WEST SUSSEX COUNTY COUNCIL CONSULTATION

TO:	Arun District Council FAO: Mr S Davis
FROM:	WSCC - Highways Authority
DATE:	27 August 2019
LOCATION:	The Cottage Piggeries Church Lane Barnham PO22 0DB
SUBJECT:	BN/47/19/PL Partial demolition of existing structures. New dwelling (1.5 storey) with separate single storey double garage. Existing mobile home to be replaced with new, smaller mobile home - This application is a Departure from the Development Plan.
DATE OF SITE VISIT:	n/a
RECOMMENDATION:	Advice
S106 CONTRIBUTION TOTAL:	n/a

Proposed Ground Floor Plan

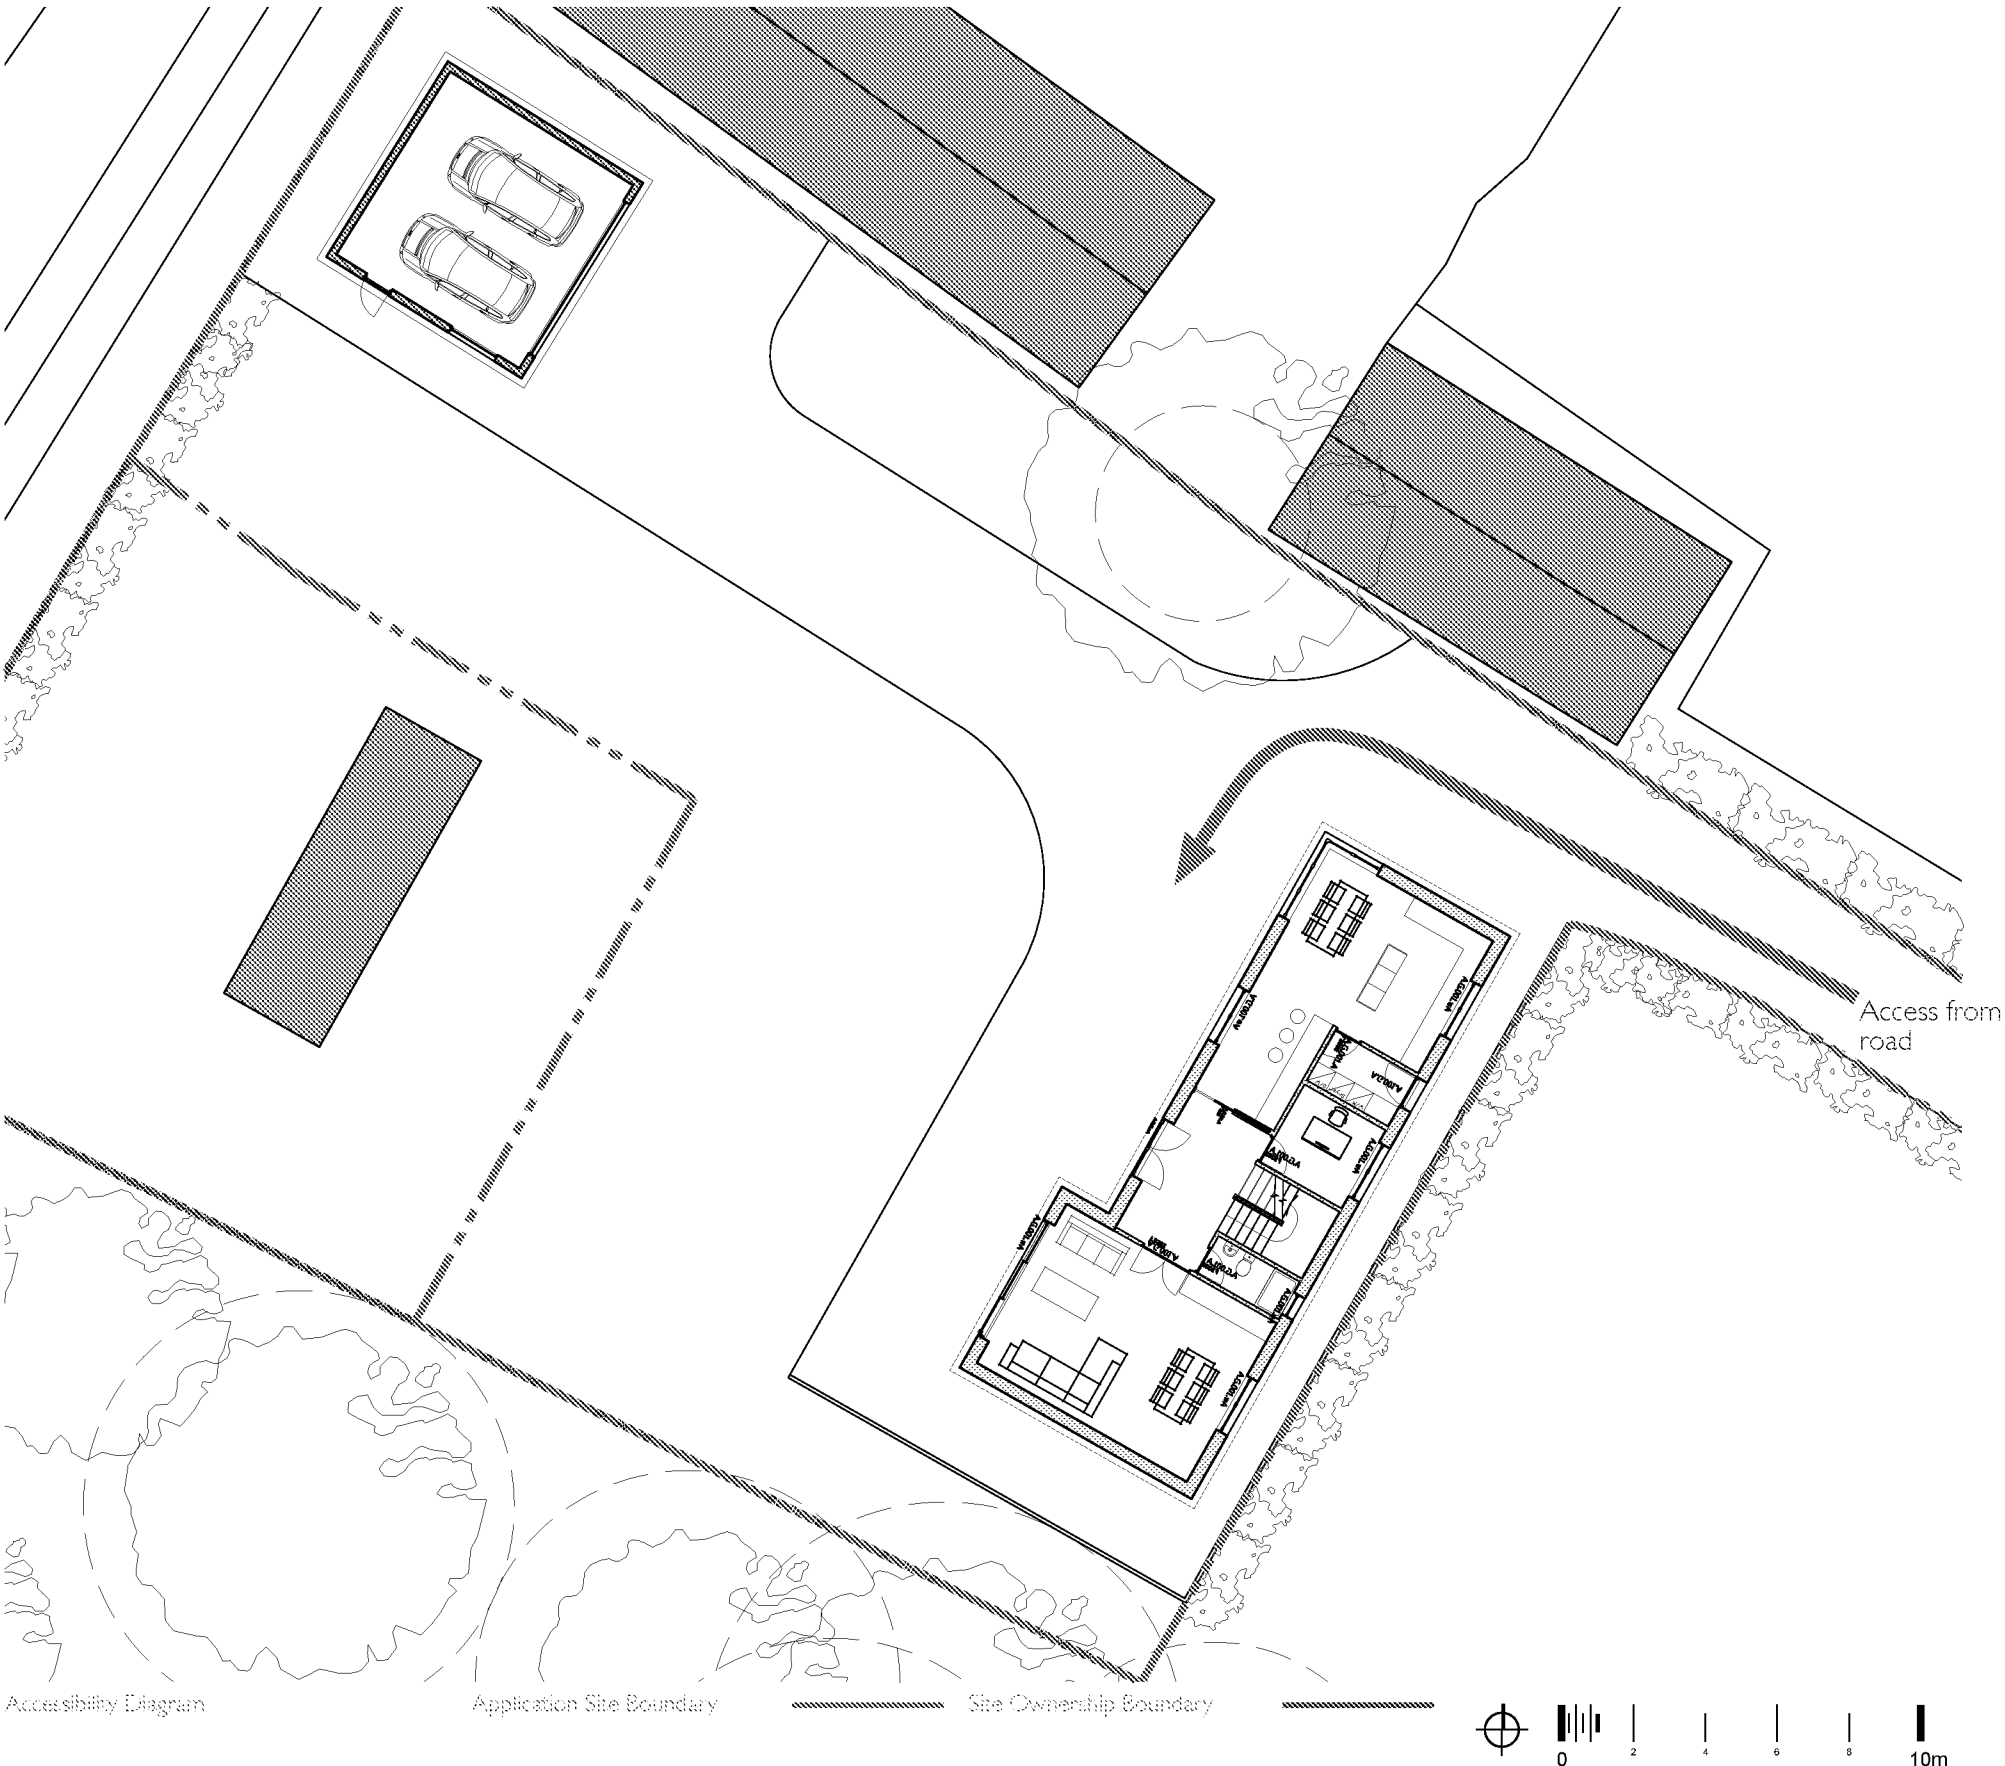
The dwellings and mobile home will be provided parking in the form of a double garage and adjacent hard standing.

The garage measure 6 x 6 metres internally. This is considered large enough to park 2 cars and cycles. This combined with the adjacent hard standing is considered an appropriate quantity of parking for a dwelling of this size in this location.

In the interests of sustainability and as result of the Government's 'Road to Zero' strategy for at least 50% of new car sales to be ultra-low emission by 2030, electric vehicle (EV) charging points should be provided for new homes. Based upon current EV sales rates within West Sussex, active charging points should be provided for a minimum of 20% of all proposed parking spaces. Ducting should be provided to the remaining 80% of parking spaces to provide 'passive' provision for these spaces to be upgraded in future. Due to the small scale nature of this proposal, the anticipated provision of active EV spaces for this development would be 1 space and should be provided in accordance with the above WSCC guidance and Arun Local Plan policy.

The adjacent hard standing also provided the opportunity to turn on site.

No part of the development shall be first occupied until the car parking has been constructed in accordance with the approved site plan. These spaces shall thereafter be retained at all times for their designated purpose.
